RWE Renewables UK Solar and Storage Limited

Planning Act 2008 – section 51 - Response to Advice following issue of acceptance decision

Application reference: EN010157

On 21 March 2025 the Planning Inspectorate (PINS) issued a decision to accept for examination a Development Consent Order Application (the DCO Application) made by RWE Solar and Storage UK Limited (the Applicant) in respect of the Peartree Hill Solar Farm (the Proposed Development).

Land plan changes

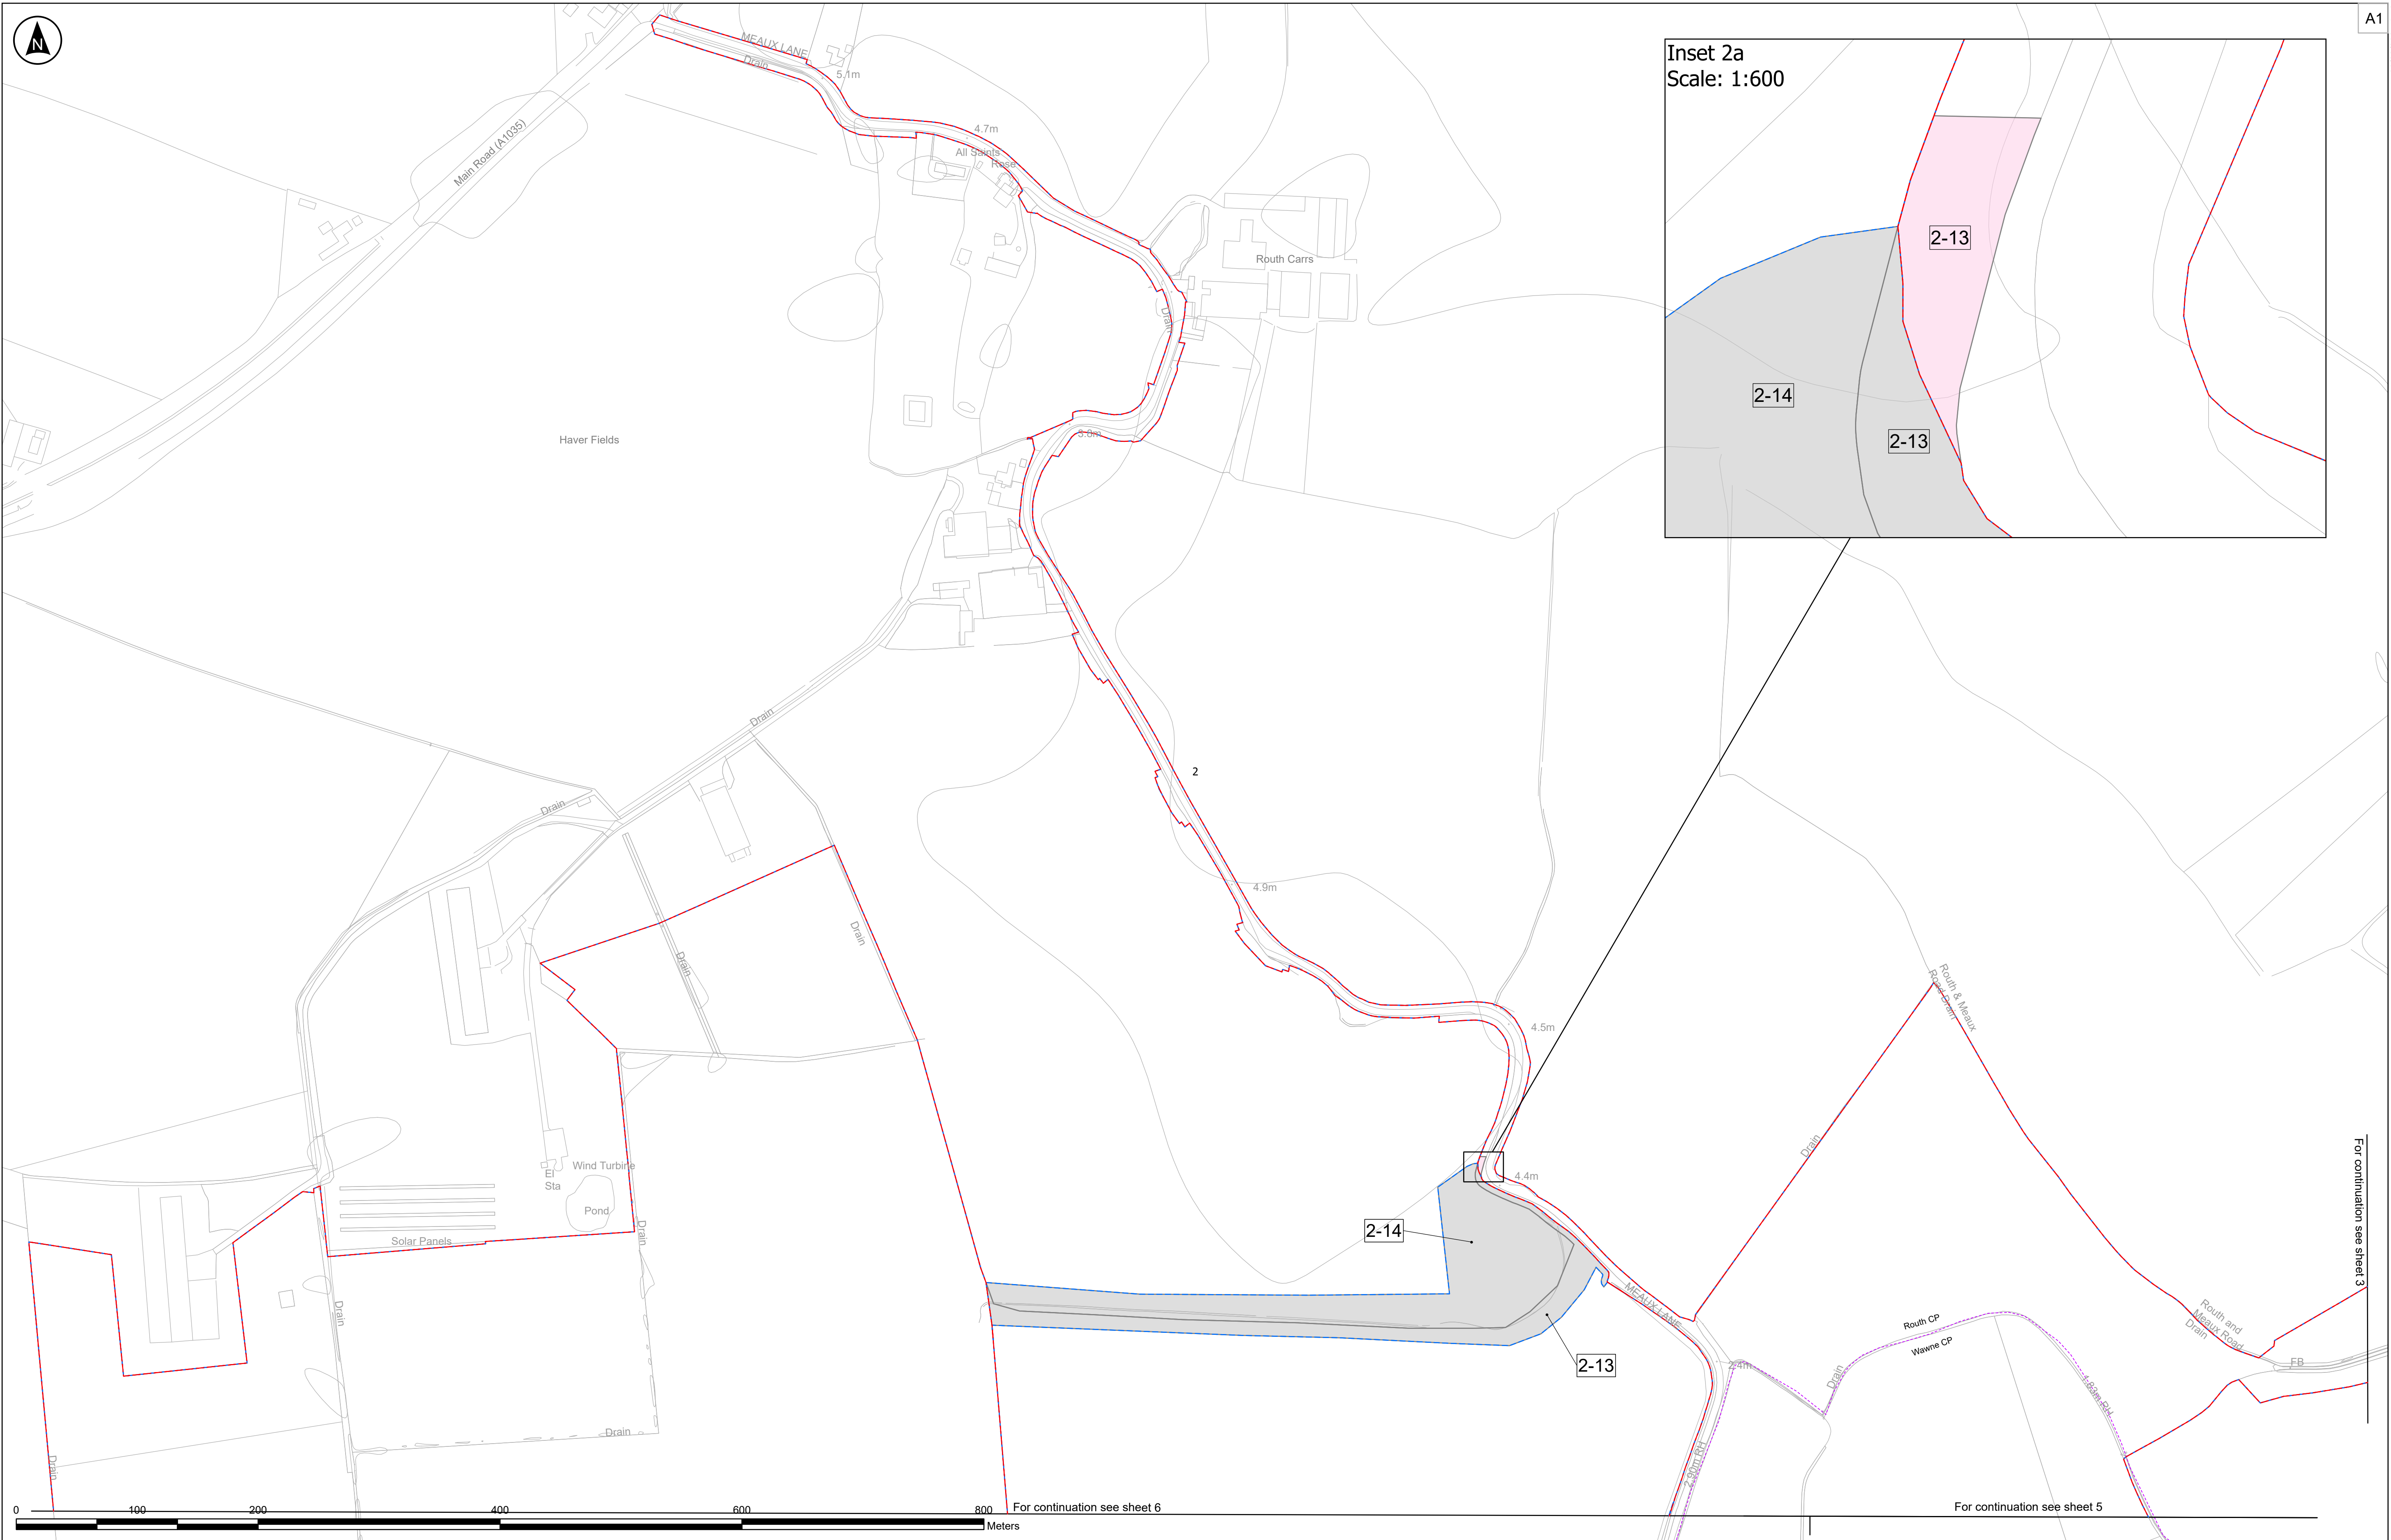
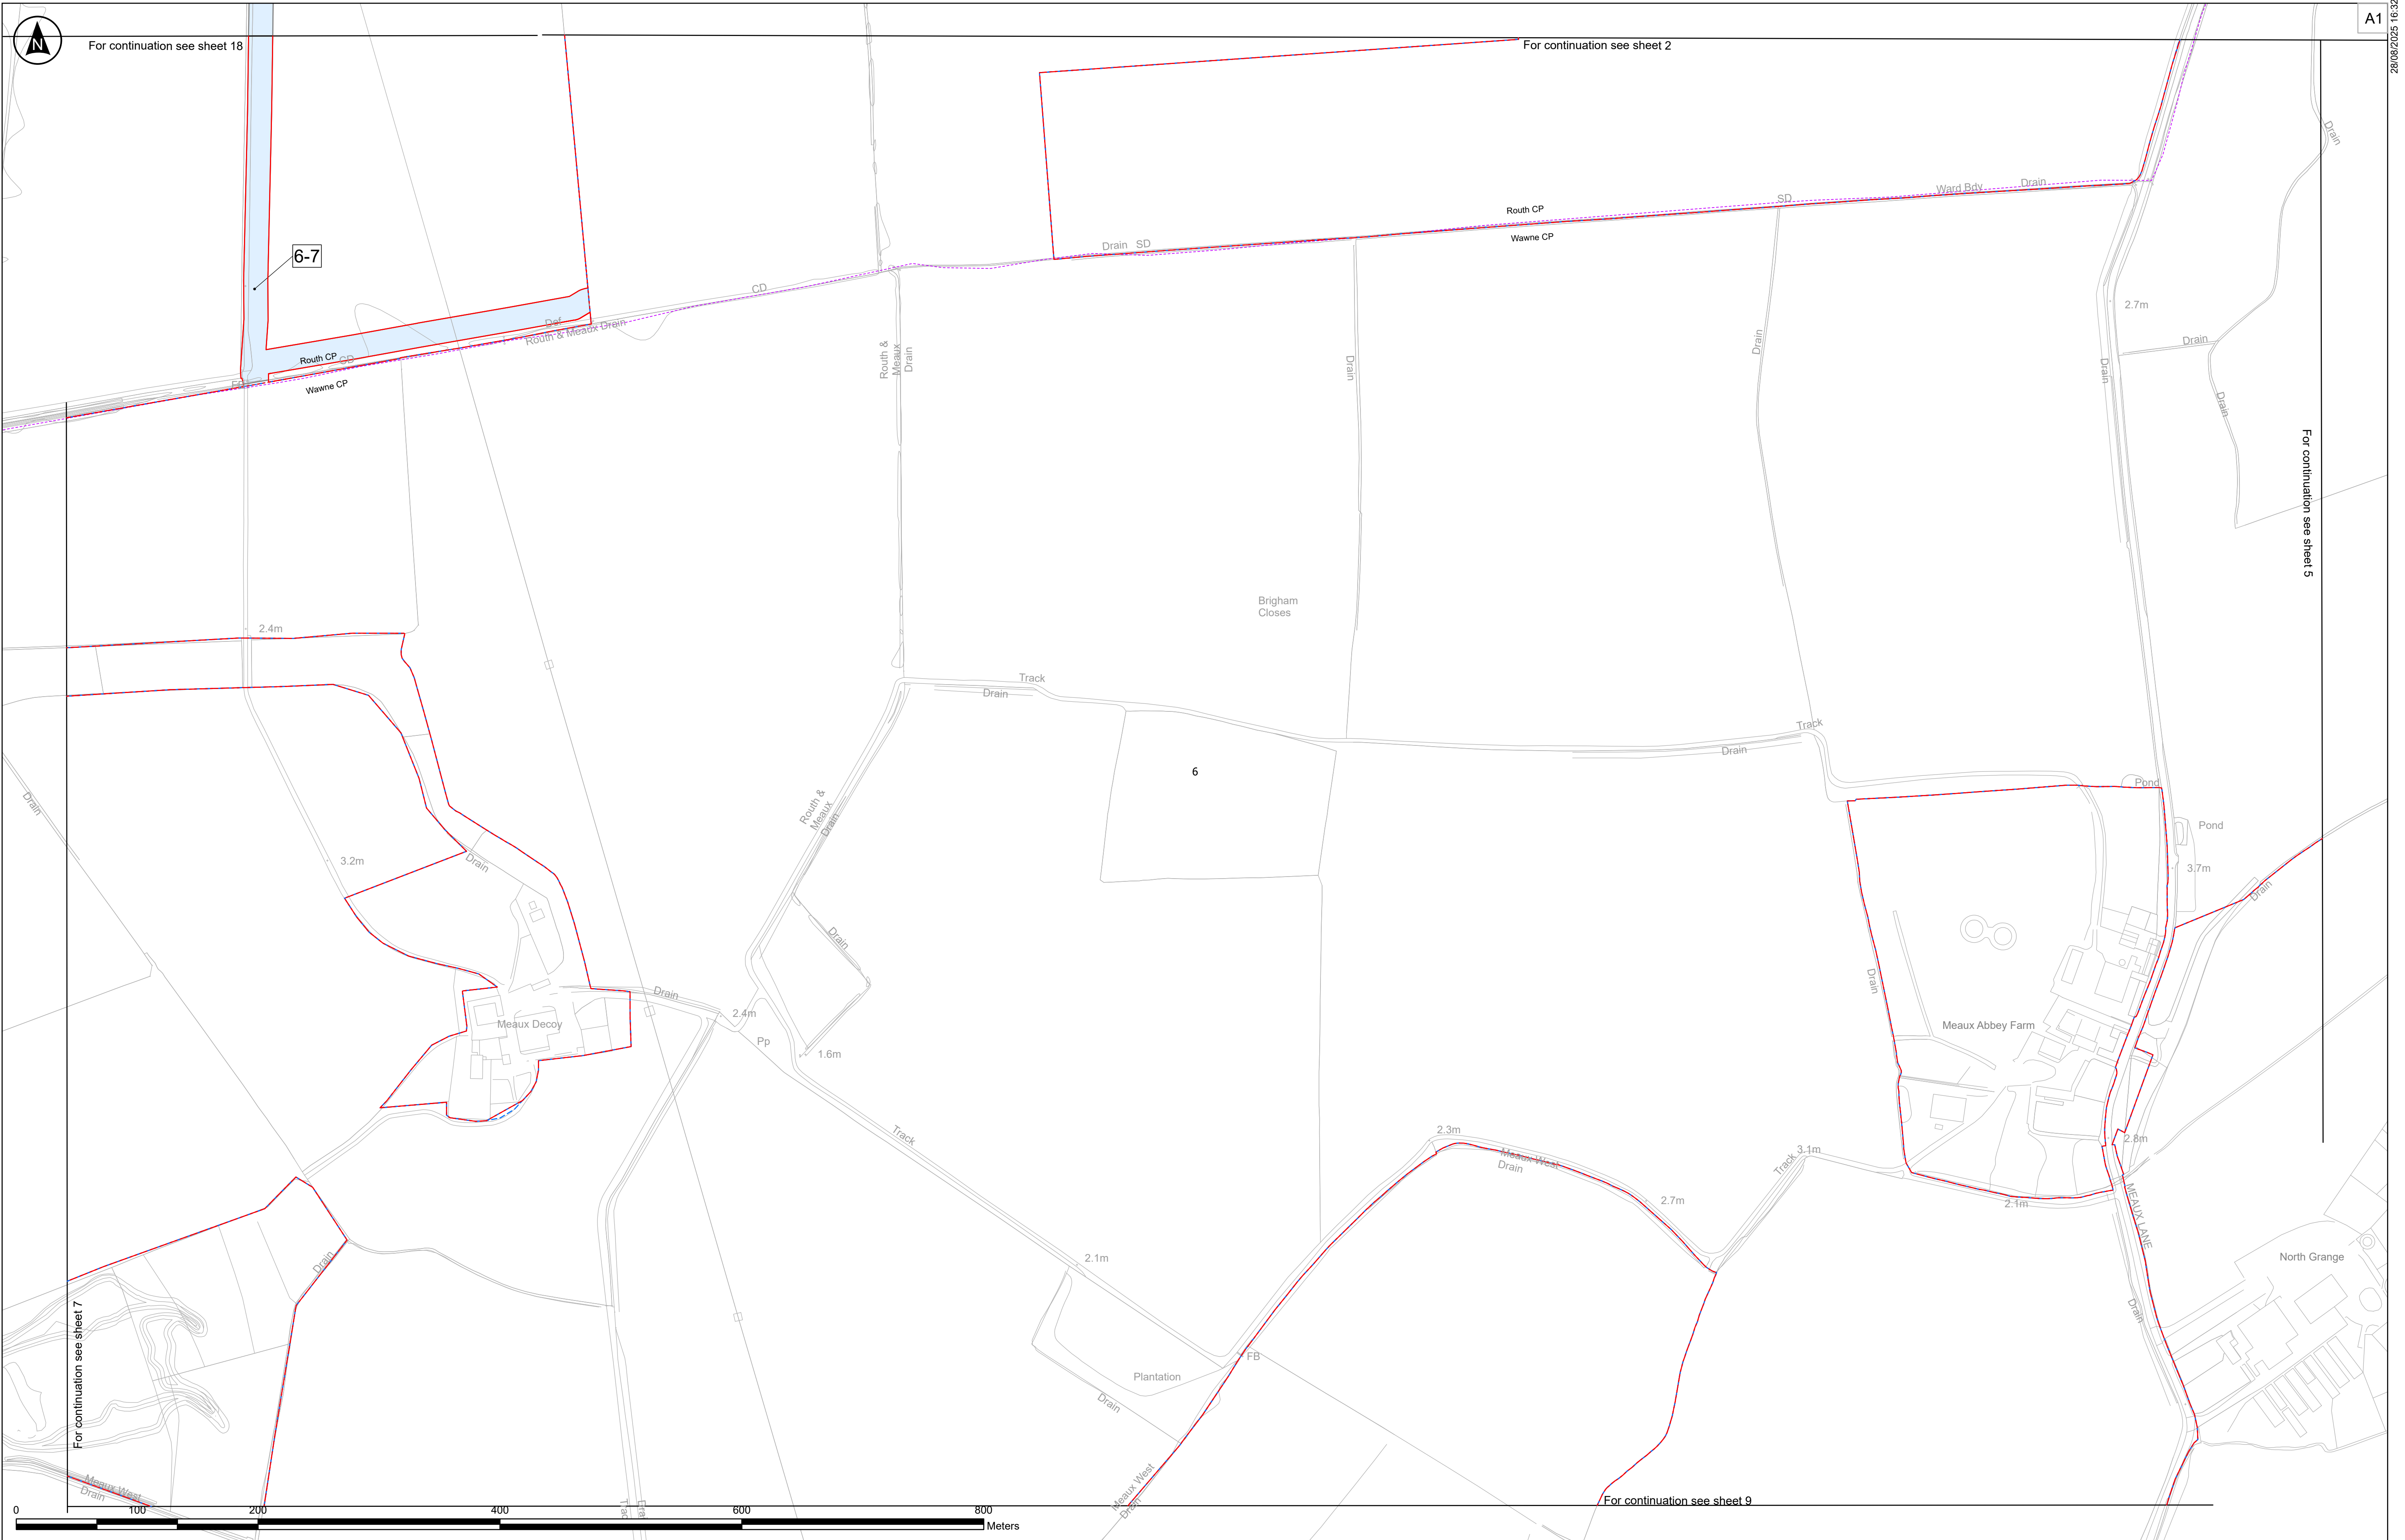
2. **Correction 2:** The Applicant also proposes to remove a section of private road (Carr Lane) that is no longer needed in connection with the Proposed Development following the relocation of the site access further west. This land will be removed from the Order Limits, resulting in a minor reduction in the scope of compulsory acquisition powers sought in respect of land. An image showing the land, identified as parcels 10-4, 10-5 and 10-6, to be removed from the Order Limits is set out below as **Figure 3**.

Figure 3 Extract of submitted Land Plans showing parcels 10-4, 10-5 and 10-6 now proposed to be removed
